# KITTITAS COUNTY

## DEPARTMENT OF PUBLIC WORKS

TO: All Staff  
FROM: Public Works Planning Review Team  
DATE: April 28, 2021  
SUBJECT: LPF-21-00005 Suncadia Phase 2 Division 6

DT-02

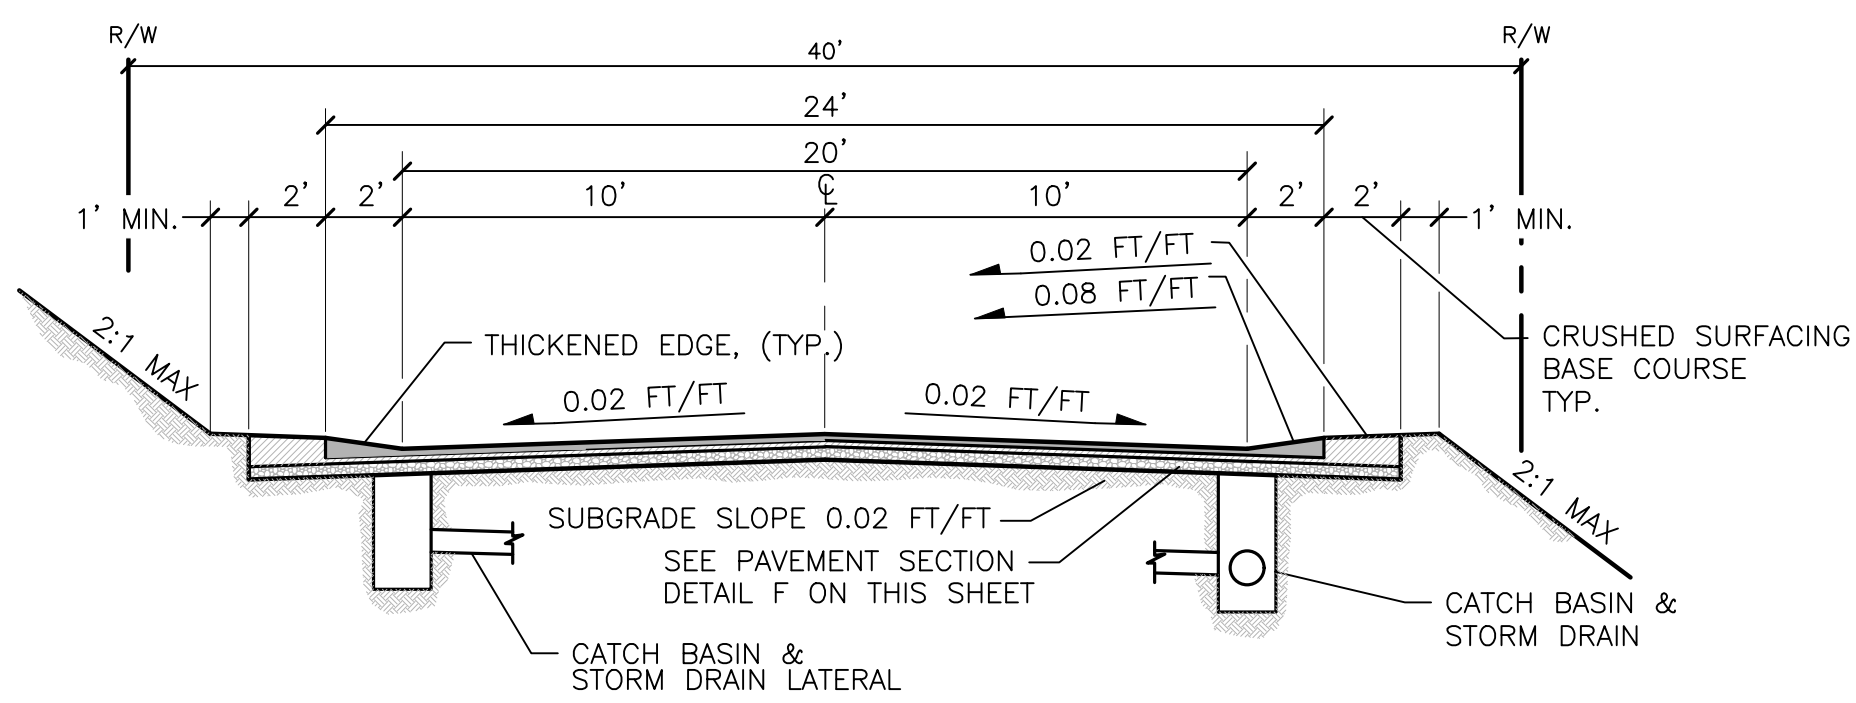
1. Within the plan set a number of pipes aren't labeled. Please be sure to label all pipes on sheets RD-01, RD-02, RD-05, and WS-02.
2. The drainage report shows that Swale 1 seems to be under sized. For the design storm shown, the swale operates with 0 free board and still overflows into a dispersion device. The report claims that the existing Basin D discharges at a flow rate of 0.543 CFS, but existing conditions do not contain any conveyance systems so existing conditions aren't discharged through a single point. The plans do show a gravel dispersion trench and an overflow spillway, was there any analysis done to verify this solution.

RESIDENTIAL ROADWAYS,
 AND JOINT UTILITY DRIVEWAY

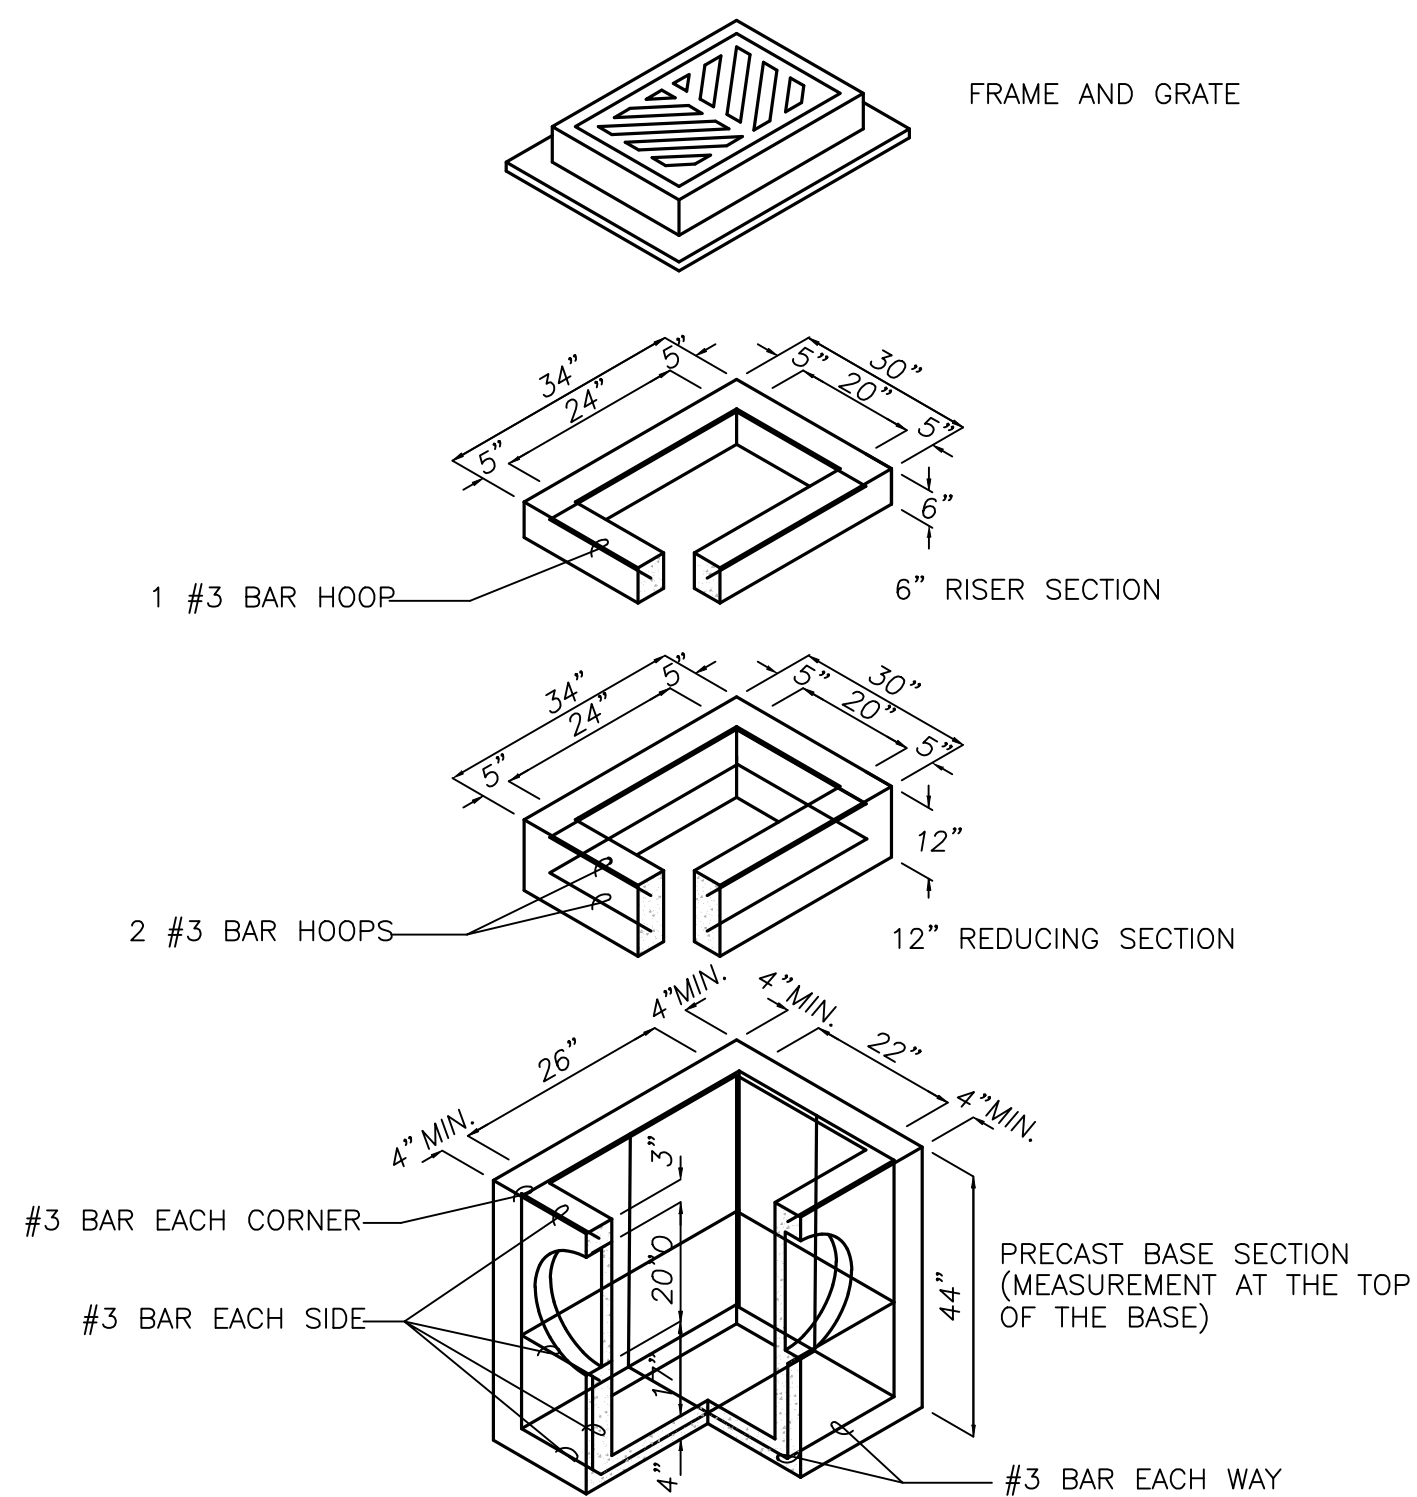
4. Please provide a cross section of the proposed roadway system.
5. The drainage report explains that SSC-6 will be met through amended soils. As in the previous submittal, please specify the approved soil on the plan set.
